Re: Submission on Cammeray Seniors Living | SSD-96505456

This submission has been prepared on behalf of Selina Poyner, the owner of 27 Rosalind Street Cammeray, which immediately adjoins the proposed seniors housing development to the east. The purpose of the submission is to raise concerns with various aspects of the proposal.

Figure 6.7: Level 4 proposed plan
Source: CHROFI 2026

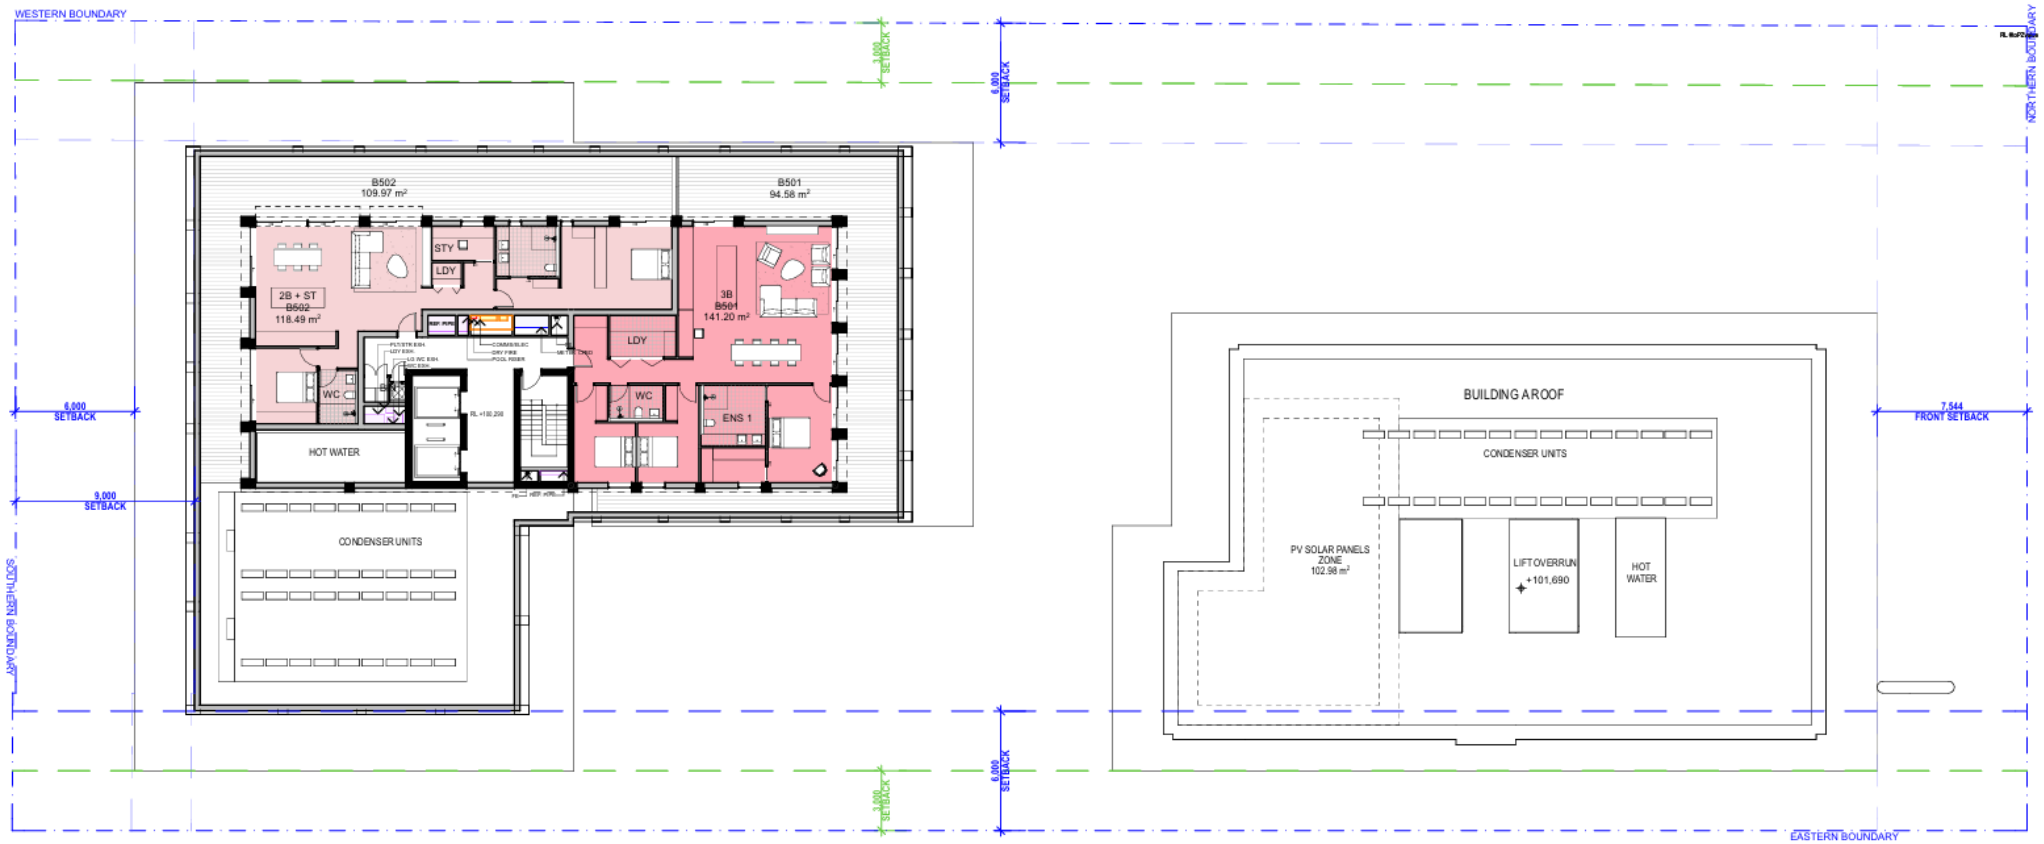
Furthermore, insufficient details have been provided to demonstrate whether the level 4 terrace shown on the architectural plans will be accessible as a wraparound terrace or whether the side portion of the terrace will be inaccessible.
